Subject: RE: BN/28/17/RES - Application for Reserved Matters - The Lillies, Yapton Road, Barnham

BN/28/17/RES - Application for the approval of Reserved Matters - The Lillies, Yapton Road, Barnham

Plots 12-13

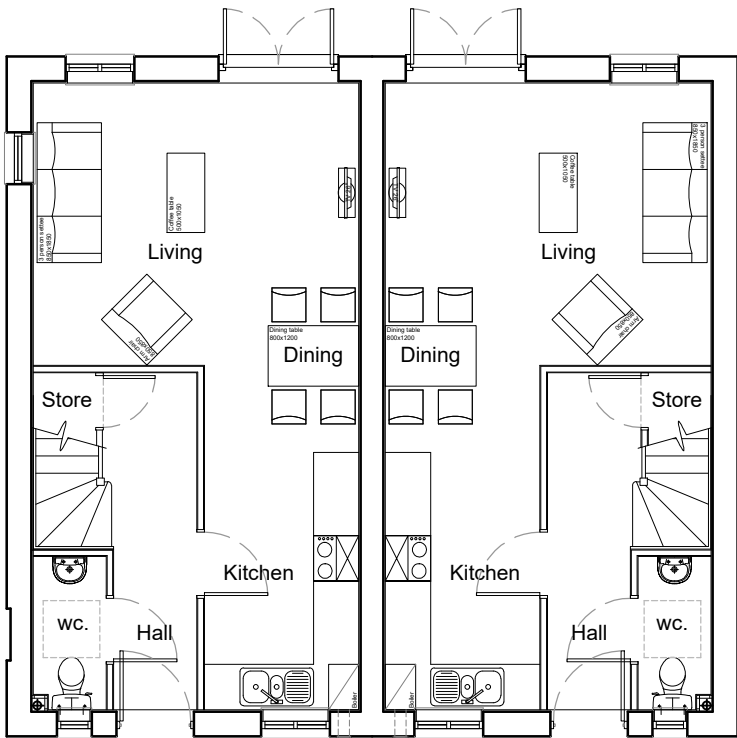
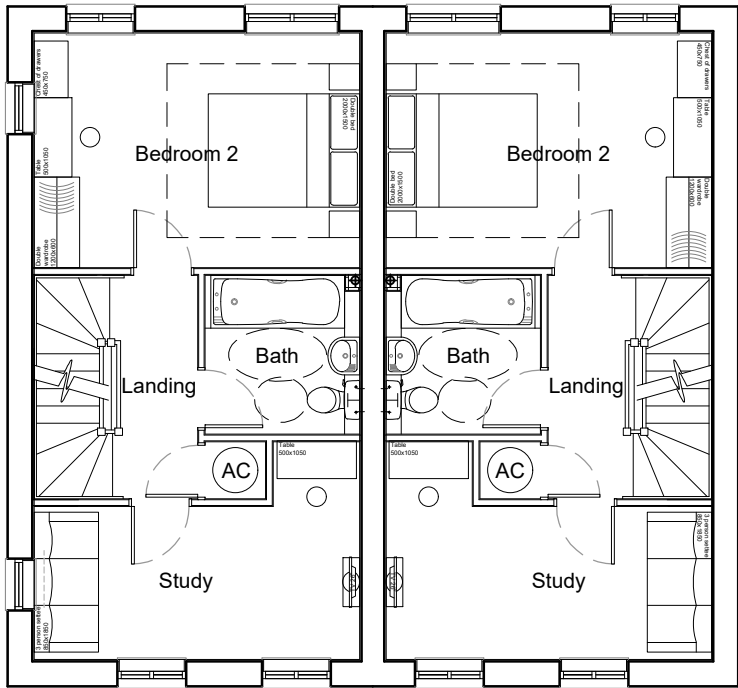
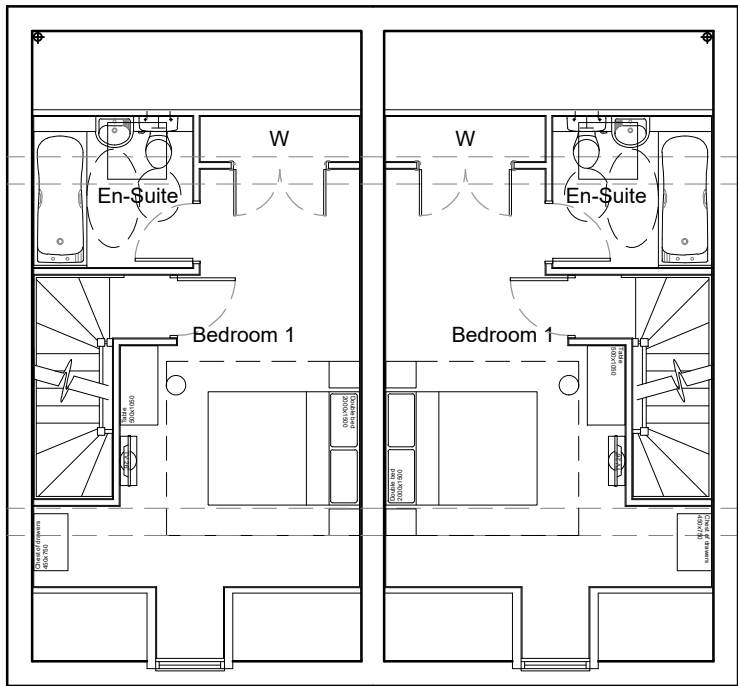
- 3) It was recommended at pre-application stage and again in an email sent by me on 16th August 2017 that the flatted building (the apartment block) be shown with some curtilage/defensible space particularly on the rear elevation which backs onto the POS. This has not been shown. The current arrangement would allow users of the POS to get right up to the ground floor windows. -- Please check the updated plans as both the coloured site layout and landscaping plans show hedging to the rear of the flat block thus creating defensible space.

- 4) It is also noted that no private space has been shown for the flats (the apartment block). Could balconies not be incorporated into the southern elevation of the building as well as the northern elevation? -- Southern elevation not possible, these have been added to the front of the building
